Application No: AB/118/20/PL
Site Address: 70A Tarrant Street Arundel BN18 9DN
Description of works: Extension to form 2 No. self contained apartments. This application may affect the setting of listed buildings, affects the character & appearance of the Arundel Conservation Area & is in CIL Zone 2 & is CIL Liable.

Thank you for your internet representation made on 20th December 2020 which has been recorded as an objection with the comments as follows:

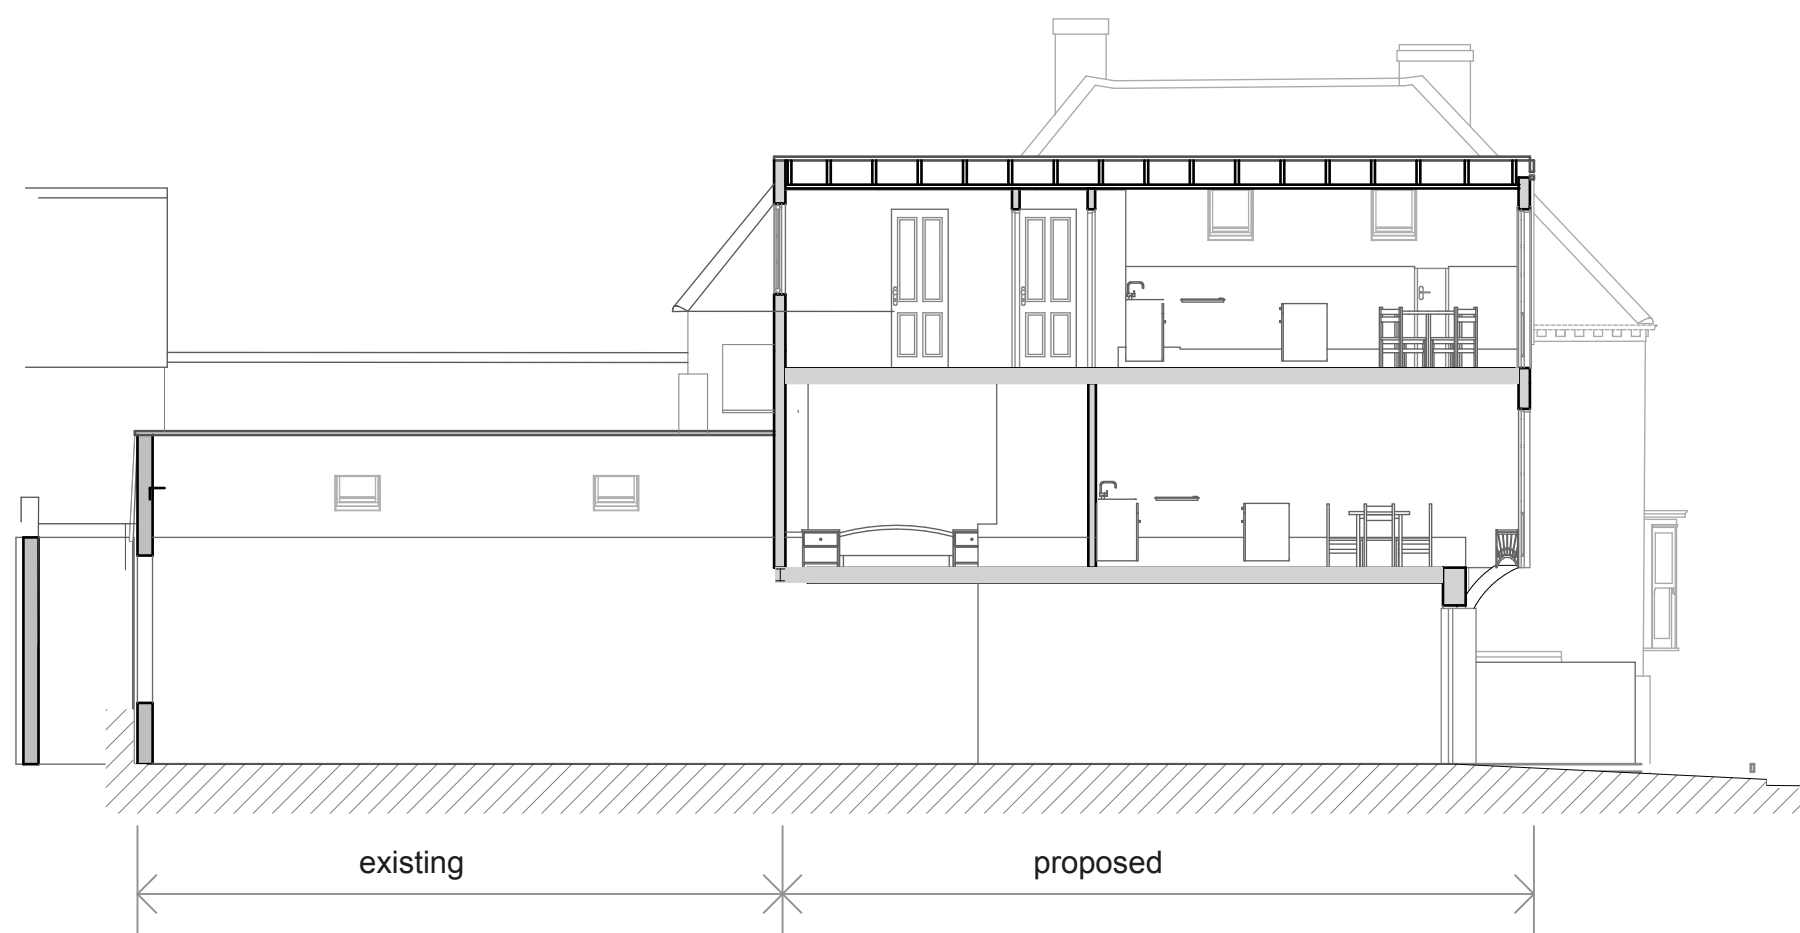
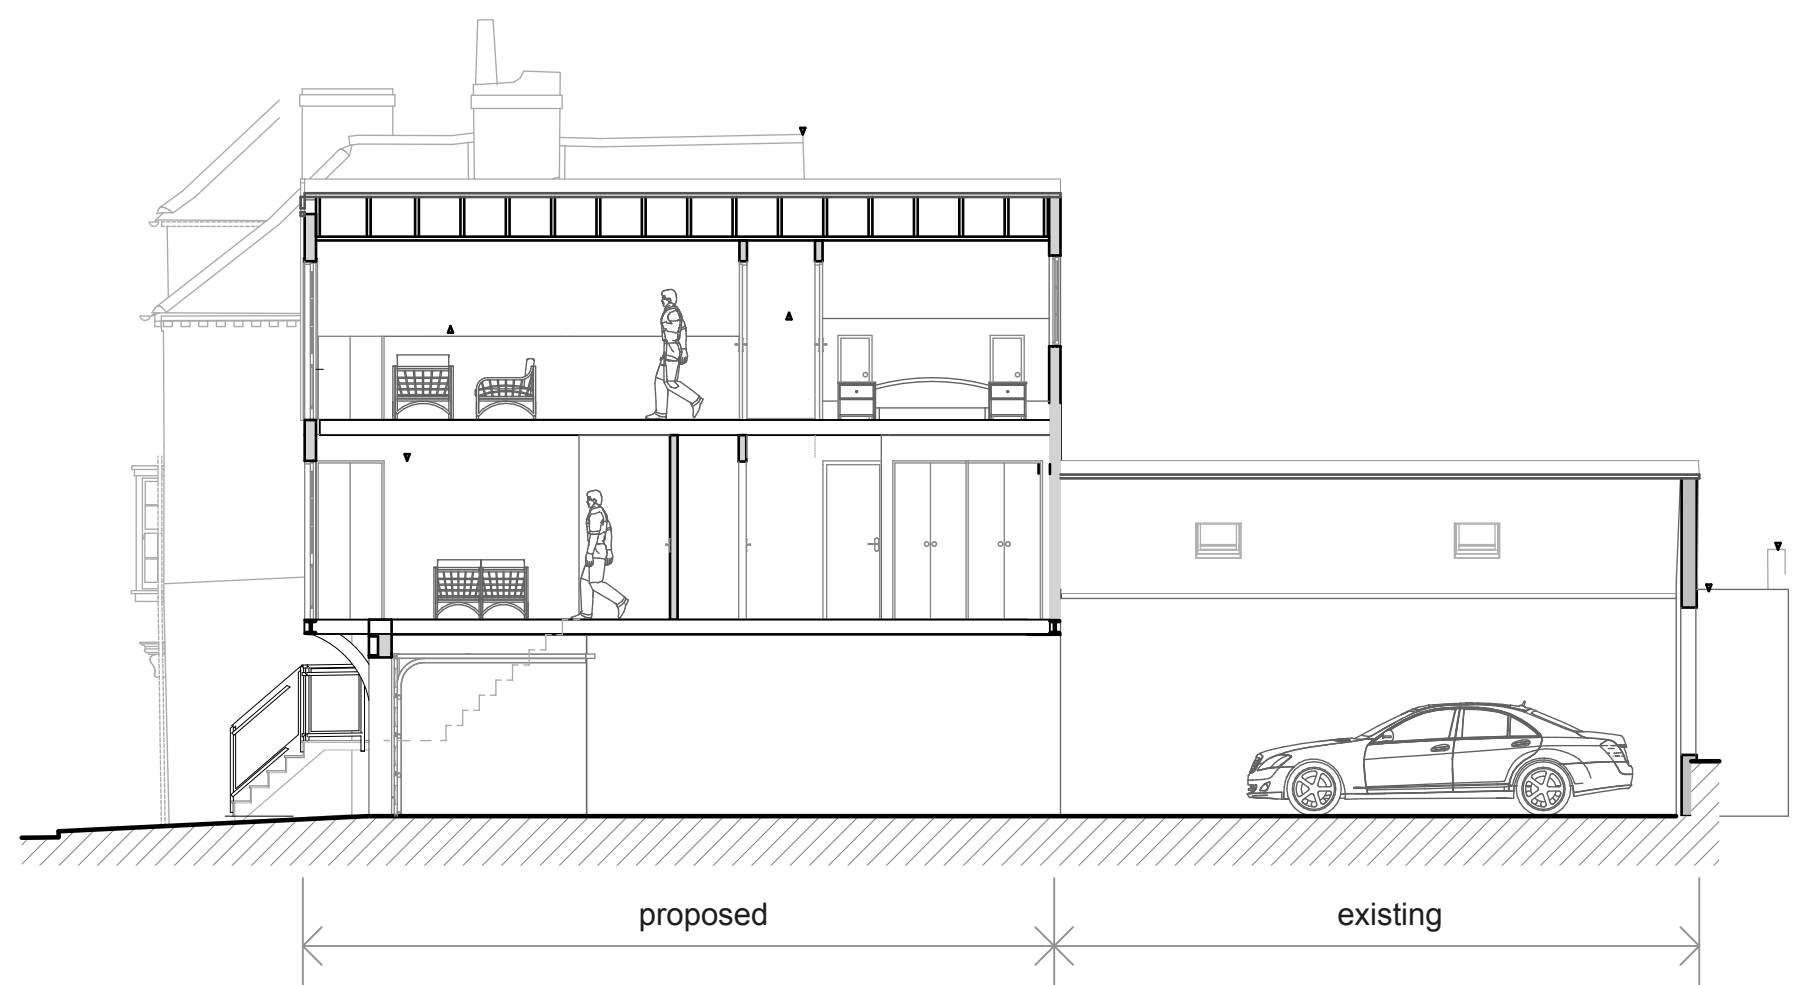
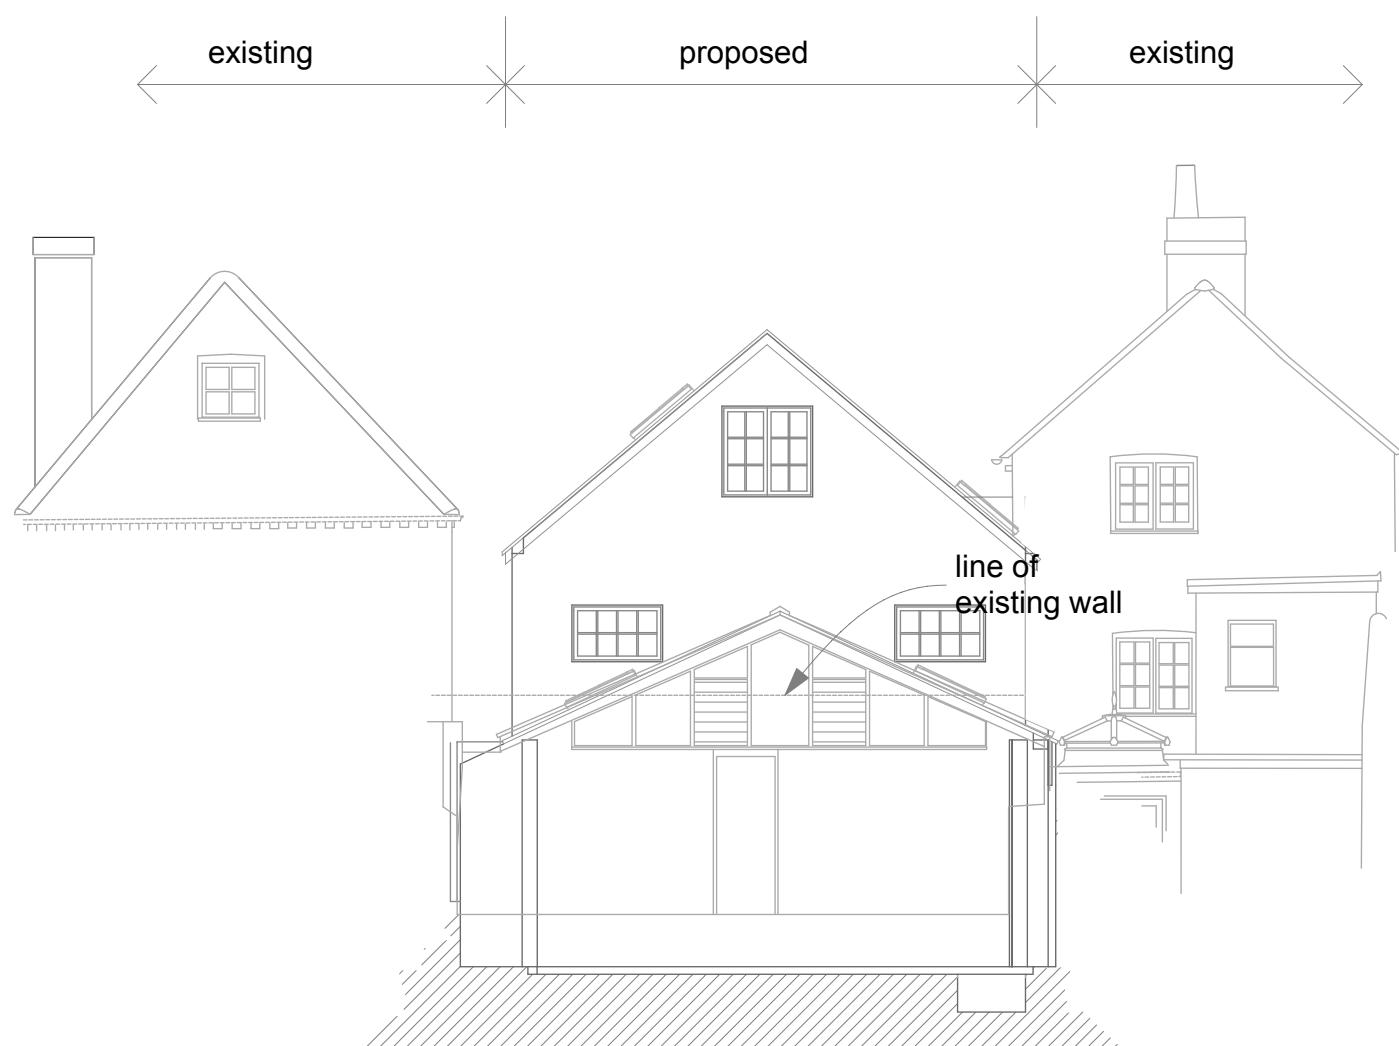
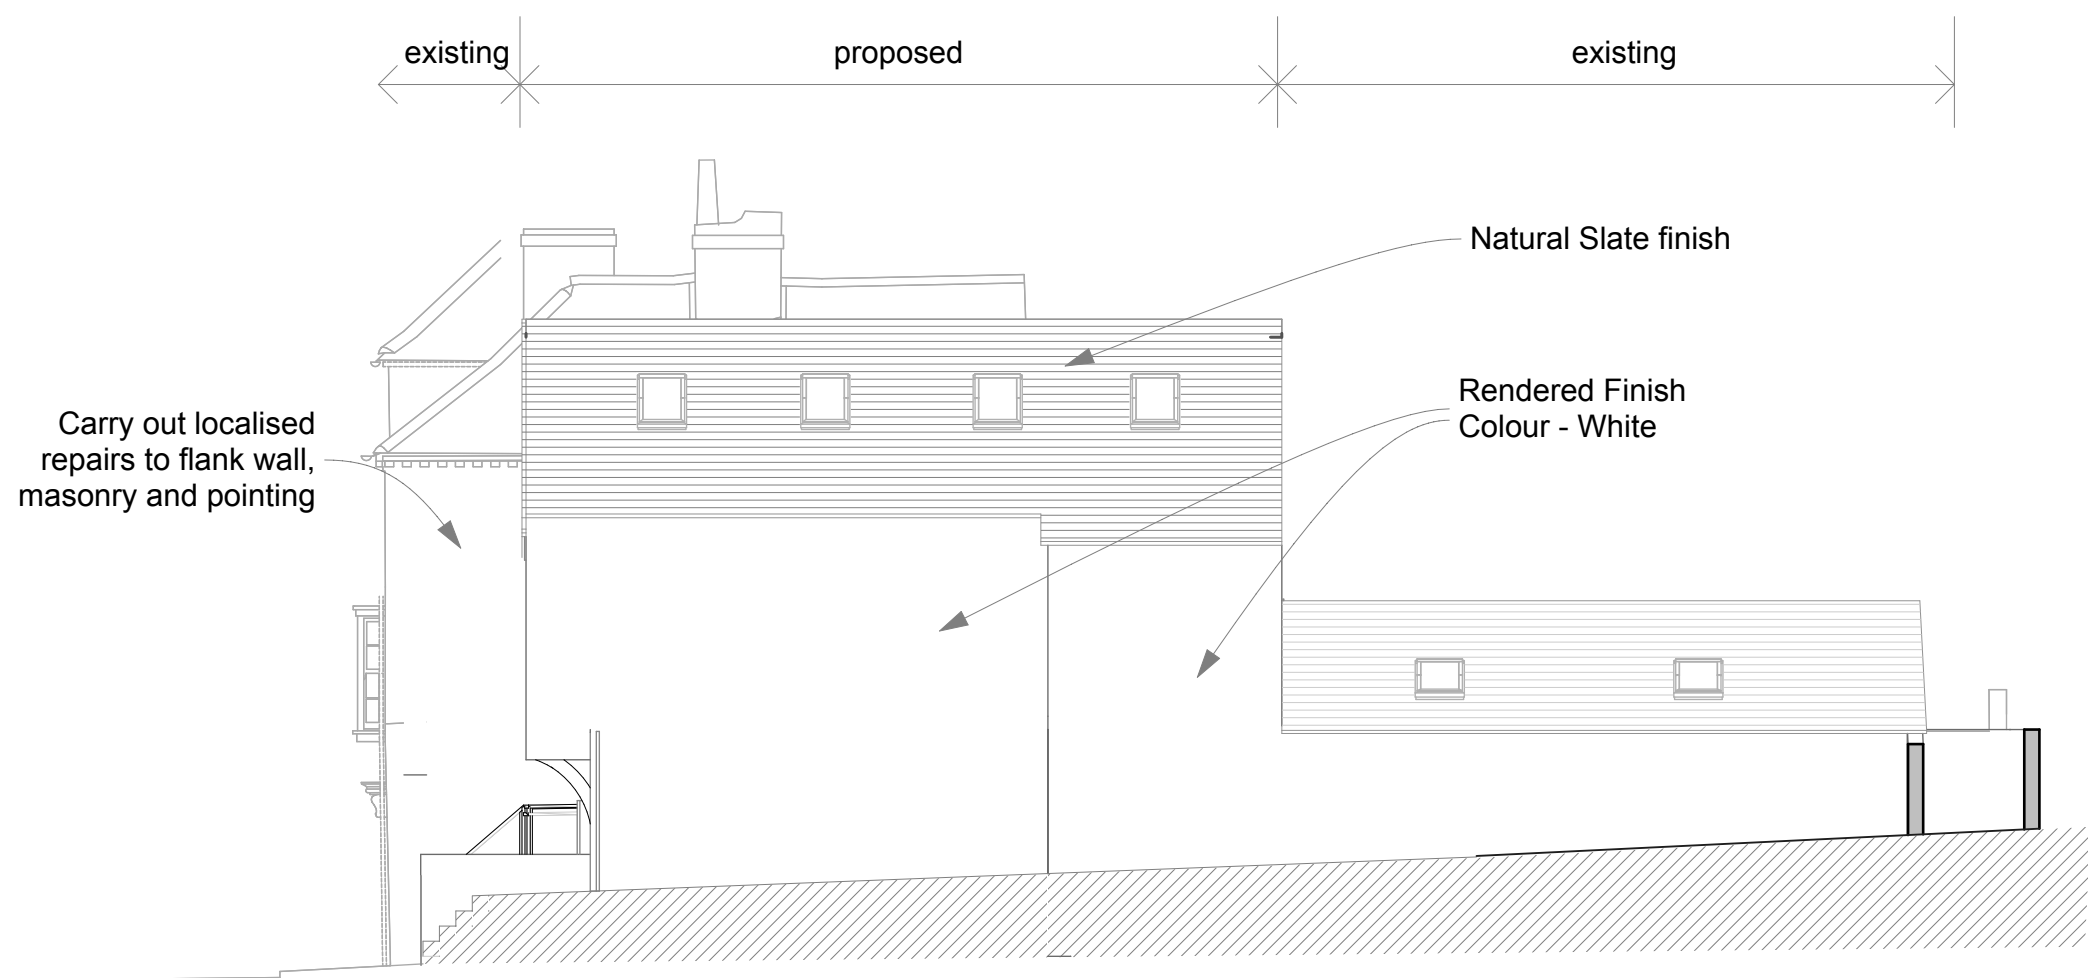
THE DATUMS will provide the needed clarification of the actual proposed ridge height which currently differs between plan 682/PL/200 Front/South-East elevations as proposed showing the top of the proposed ridge the same height as ridge to Number 70 or the much lower ridge height shown on plan 181390/05 with title Sections - proposed.

- a) There is overlooking from the new north elevation containing 3 No large new windows (Not dimensioned).
- b) There is additional overlooking into Number 64 and its neighbours from 4 roof lights without dimensions in the east elevation of the main sloping roof.
- c) There is no west elevation of the new main roof shown on the plans whilst section A of 181390/04 appears to show in section only what may be a single roof light or many roof lights which will overlook Number 70 and its neighbours.
